From: Erin Moore
Sent: Friday, October 25, 2013 4:17 PM
To: Jeff Watson
Subject: FW: BL-13-00017 Berger

[BL-13-00017 Berger](#)

RECORD OF SURVEY
PORTIONS OF THE NE 1/4 OF SEC. 35 & THE NW 1/4 OF SEC. 36,
TOWNSHIP 20 NORTH, RANGE 14 EAST, W.M.,
KITITAS COUNTY, WASHINGTON

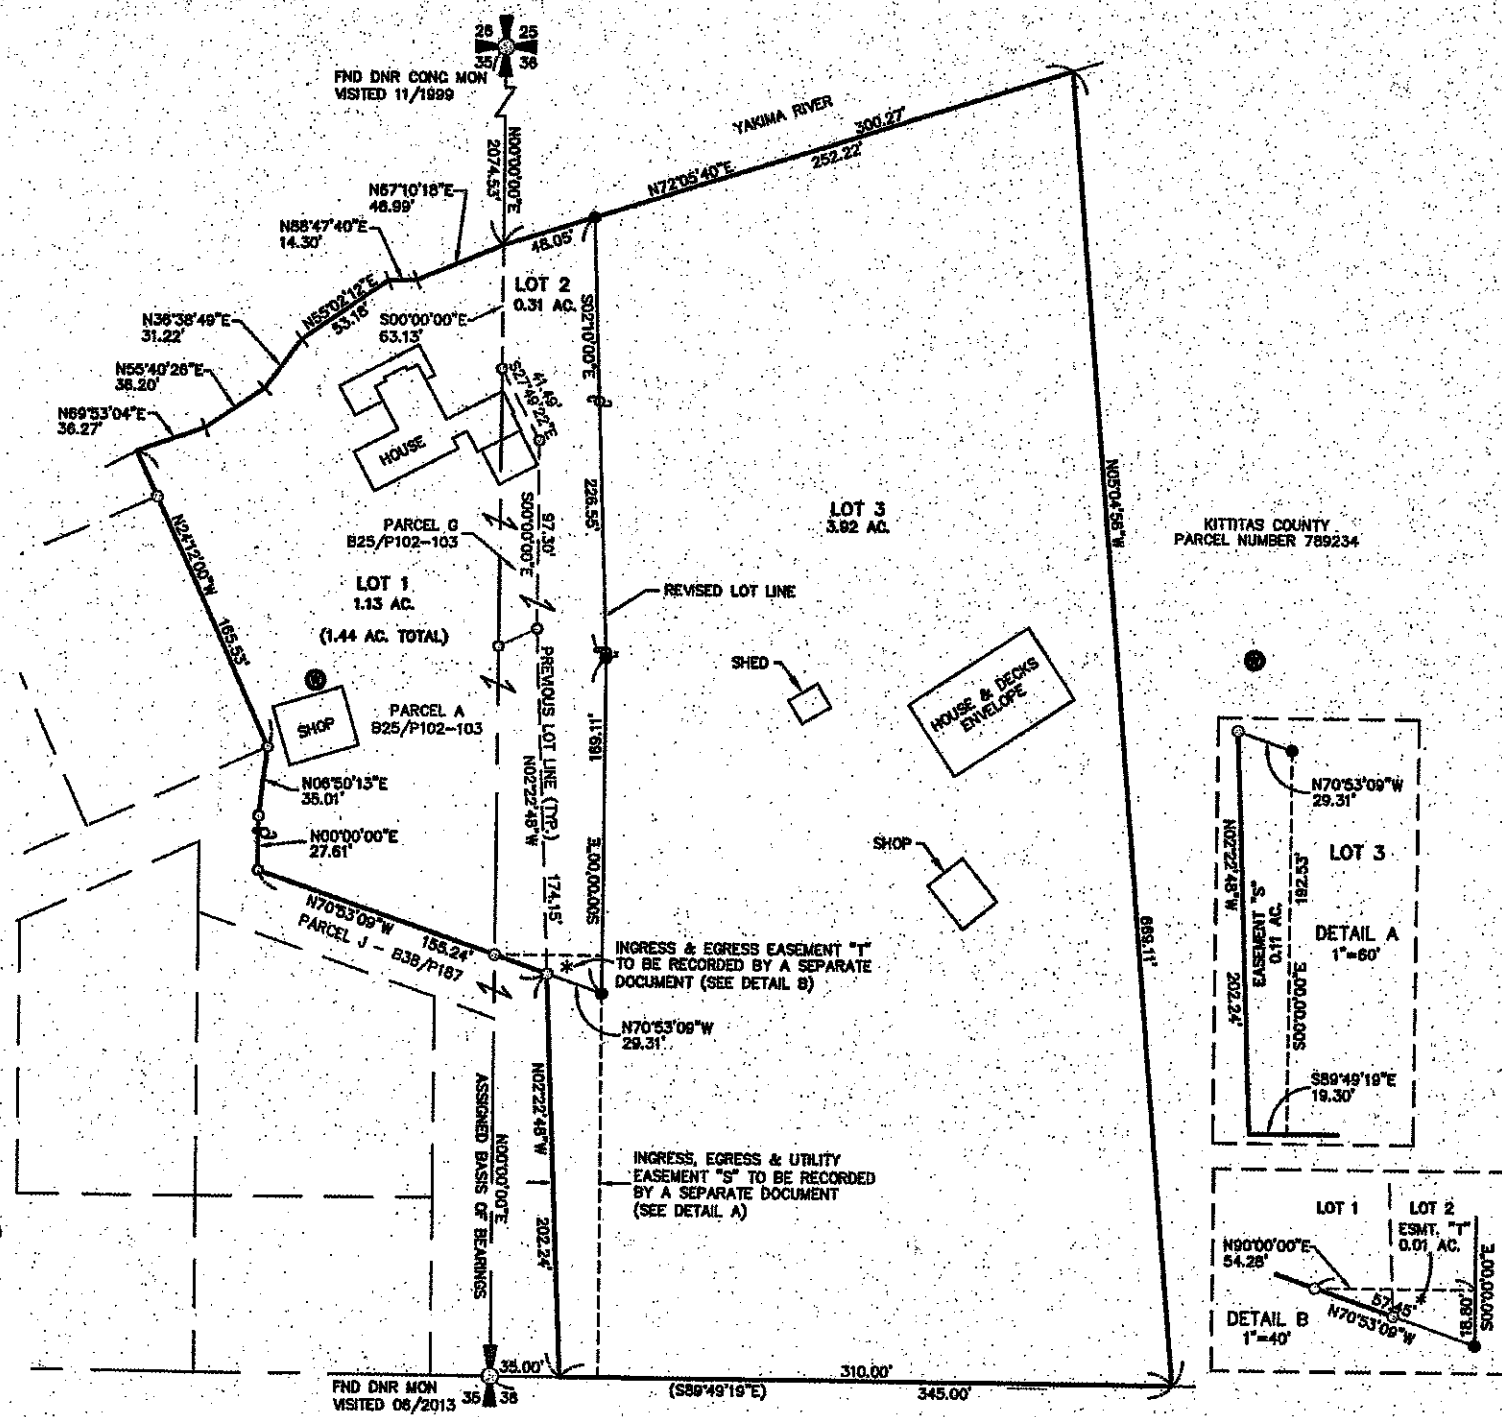
The proposed lot line doesn't interfere with the well next to the shop. I am just curious if it is a shared well situation.

I could have sworn I sent this to you. We need to know where the well is (are) on this one.

Ken Hodge shares a well with the neighbor to the East. That well is shown on the recorded survey on the neighbor's property. The well shown by Mr. Berger's shop is not a shared well. This well is for the sole use of the Berger property. The boundary line adjustment does not affect either well.
